**KIRKLEES METROPOLITAN COUNCIL
INVESTMENT & REGENERATION SERVICE**

Reference No:	2024/62/90099/W
Site Address:	Mellbreak, 161, Causeway Side, Linthwaite, Huddersfield, HD7 5SJ
Description:	Erection of dormer windows and orangery to rear (within a Conservation Area)
Recommending Officer:	Laura Yeadon

DECISION – REFUSED

Officer Report

Drawing Title:  
Existing Elevations

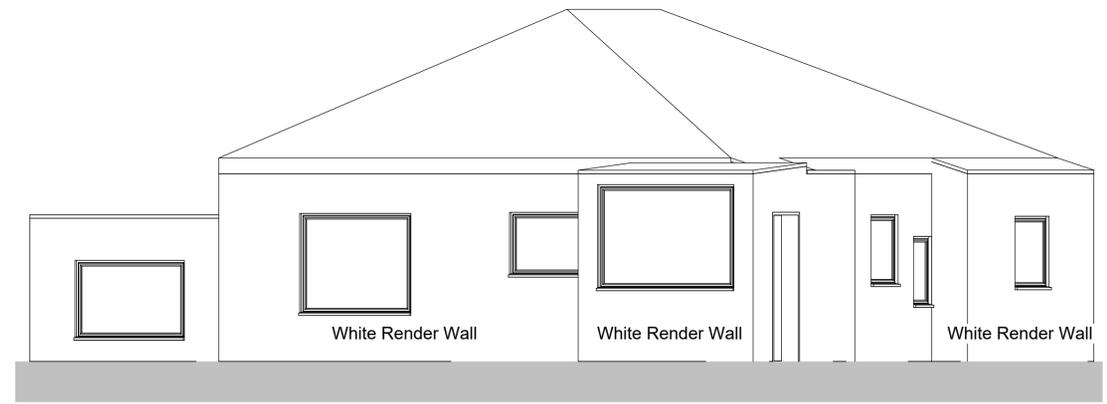
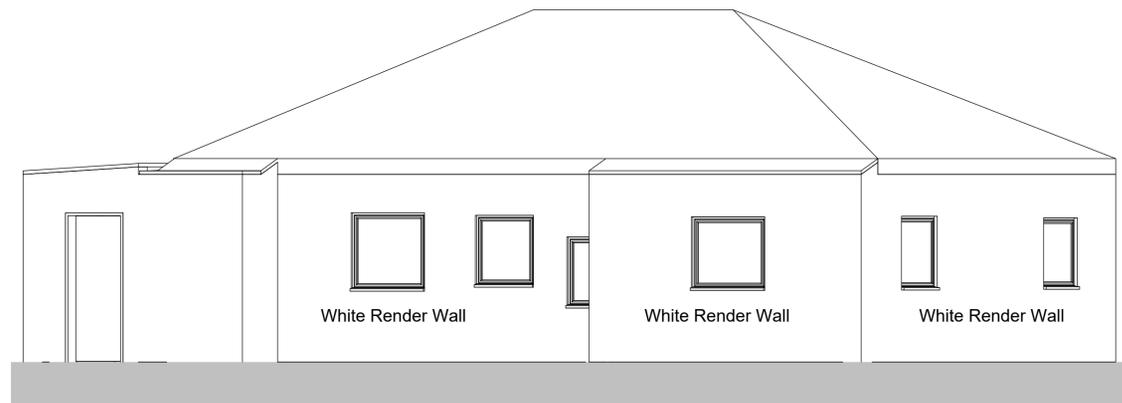
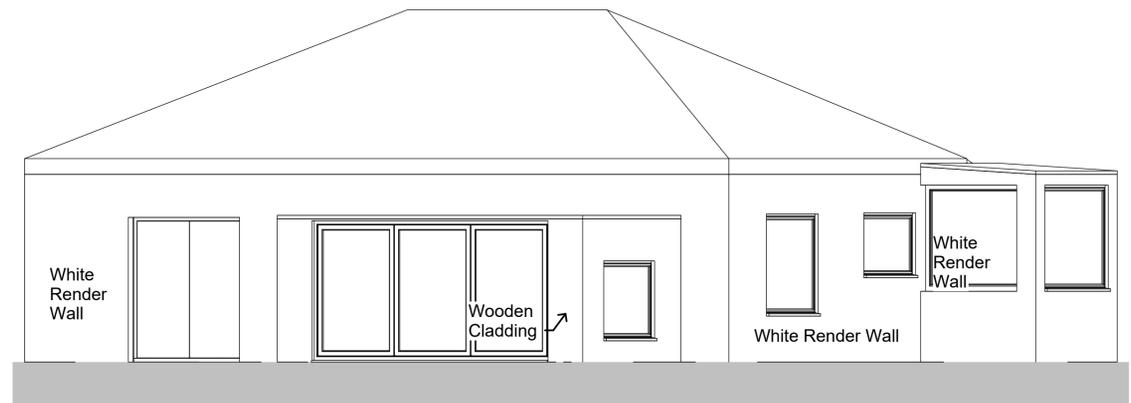
The design of the proposed dormer is a very large and dominant structure which is more akin to a flat roof first floor extension to the bungalow. Due to the projection from the sides of the original roof slope, the resultant structure introduces a very large, overly prominent structure which, due to its size and finishing material is not a subservient design which is in keeping with the original design principles of the host property and is out of keeping with the wider character of the locality.

The large, flat roofed dormer does not meet the criteria of sub-paragraph 5.26 of the SPD insofar as it is not in keeping with other dormers within the street scene which are small in scale and sit comfortably within the existing roof slopes. The large dormer, due to its size and scale has the appearance of a partially flat roofed dwelling which does not respect or enhance the character of the property. The SPD is clear that modern flat roof dormers may be acceptable if they are well-designed, small in scale and appearance and are characteristic of the street scene. In addition, they should not dominate the roof should be set below the ridgeline of the roof. The development fails to meet these points of the SPD. Instead, it is considered that by virtue of its siting, scale and form, the dormer poorly relates to the appearance of the house and dominates the extended roof causing detrimental harm to the visual amenities

As the works have been carried out on site, the impact of the scheme is clearly apparent. Whilst the dormer is located to the rear, the full height structure which is more akin to a first floor extension has a significant impact and is clearly visible.

However, due to floor levels, the extension is set up significantly above the ground level and upon a terraced area. As noted above, Officer's note that the terrace and outbuilding constructed on site do not form part of this application and planning permission is required to regularise these works (or the removal of the terrace).

The level of underbuild which is required to be provided to support the rear extension is clearly substantial and if not sympathetic to the setting and wider locality has a harmful impact upon the character of the Conservation Area and the wider visual amenity of the locality. The rear of the building is visible from the highway and a number of properties to the west and north of the site. The construction of a single storey extension upon 'stilts' would be out of character with the locality. The large expansive terrace which has been constructed is considered to be out of keeping with the locality and have a harmful impact

1. By virtue of its materials of construction, associated engineering works, siting, scale, massing, prominence and design, the development is not a subservient addition and poorly relates to the appearance of the host property having a harmful impact upon the visual amenities of the host property and wider locality as well as the character, appearance and setting of the Linthwaite Conservation Area and neighbouring Listed Buildings. The development has led to substantial harm for which no public benefits have been demonstrated to outweigh the harm. The development is contrary to policies LP2, LP24 (a and c) and Policy LP35 of the Kirklees Local Plan, Key Design principles 1 and 2 of the Council's
